COUNTY COUNCIL'S RESPONSE TO CONSULTATION ON THE FOLLOWING DEVELOPMENT PROPOSAL

Application no: 17/02394/OUT-2

Location: East Of Last House Adjoining And North Of Berry Hill Road, Adderbury

Proposal: Outline planning permission for up to 53 dwellings with associated landscaping, open space and vehicular access off Berry Hill Road.

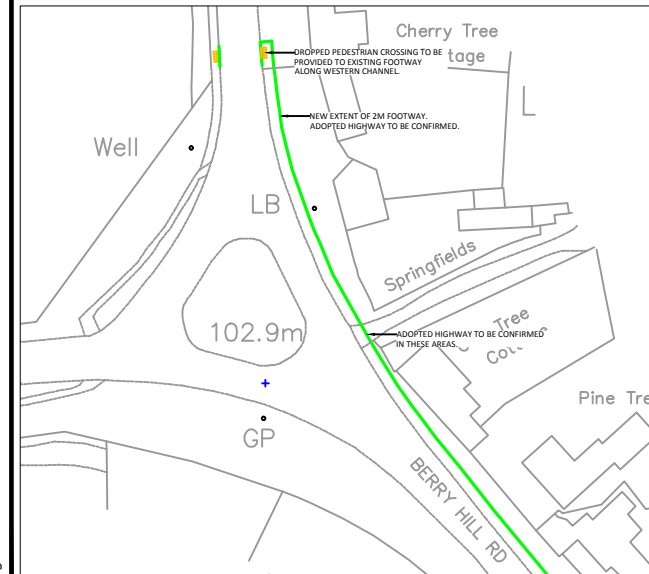
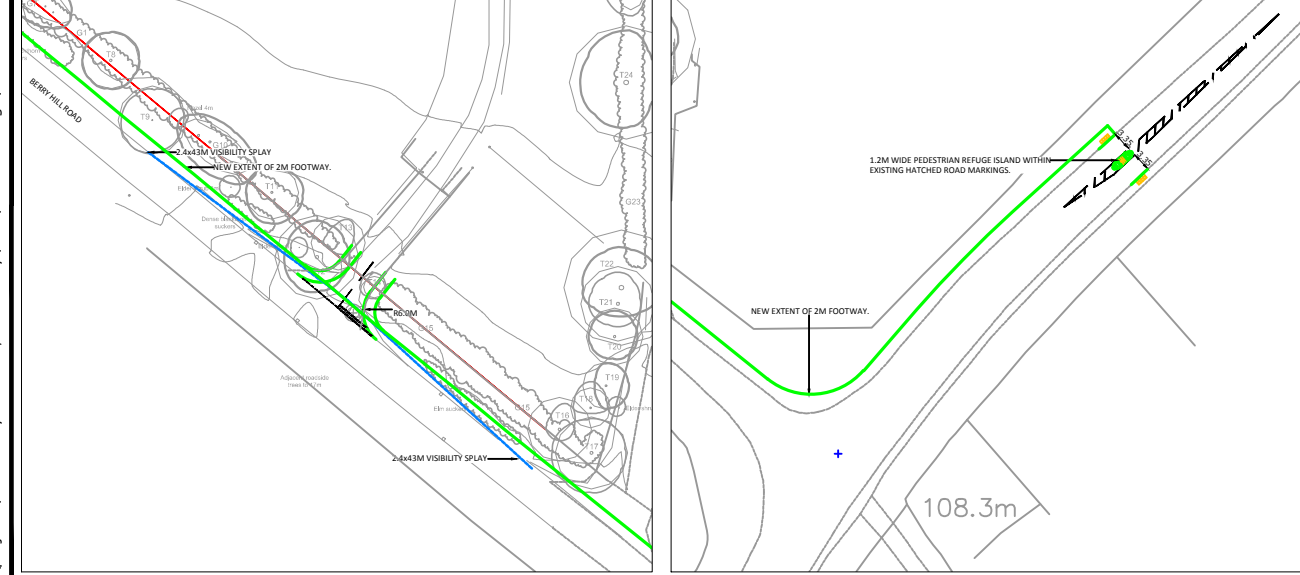
The document "Response to Highway Comments – February 2018" points out that **Drawing No.1899-F01 Revision A** shows the extent of highway land on Berry Hill Road and notes *"The plan clearly shows that the new footway can be accommodated within the extent of adopted highway."* However, the extent of highway land shown on drawing No.1899-F01 Revision A does not reach as far as the intended tie in with the existing footway on Horn Hill Road. Furthermore, revised **Drawing No.1899-F01 Revision B** still notes *"Adopted highway to be confirmed"* to the north of the extent of highway land shown. This still suggests that the feasibility of a footway linking the development site with the existing footway on Horn Hill Road is not established. This footway is regarded as an essential provision for a development site with relatively poor sustainability credentials and its deliverability must be established. **Reason for objection.**

- The developer needs to check the highway boundary. It is almost certainly the roadside edge of the ditch but this can vary locally. If the highway boundary is the roadside edge of the ditch then a 2.0m footway may be difficult to achieve, and the ditch may need piping or the footway/road retaining in some way.

- The drawing in the TA showing the visibility splays is not same plan as the separately submitted access plan. **Reason for objection.**
- The highway tree just to the north west of the proposed access might be in visibility splay or even in the construction so this requires checking with the tree team if it is acceptable to remove. **Reason for objection.**

- The County has requested visibility splays to be compliant with the Design Manual for Roads and Bridges (DMRB) rather than the Manual for Streets (MfS). The document “Response to Highway Comments – February 2018” states that *“These are shown on the Site Access plan on **Drawing Number 1899-F01 Revision A** and are shown to be achievable on land within the site or on adopted highway.”* However, both **Drawing Nos.1899-F01 Revision A and Revision B** both still show MfS compliant visibility splays only. DMRB visibility compliant visibility splays are required. **Reason for objection.**
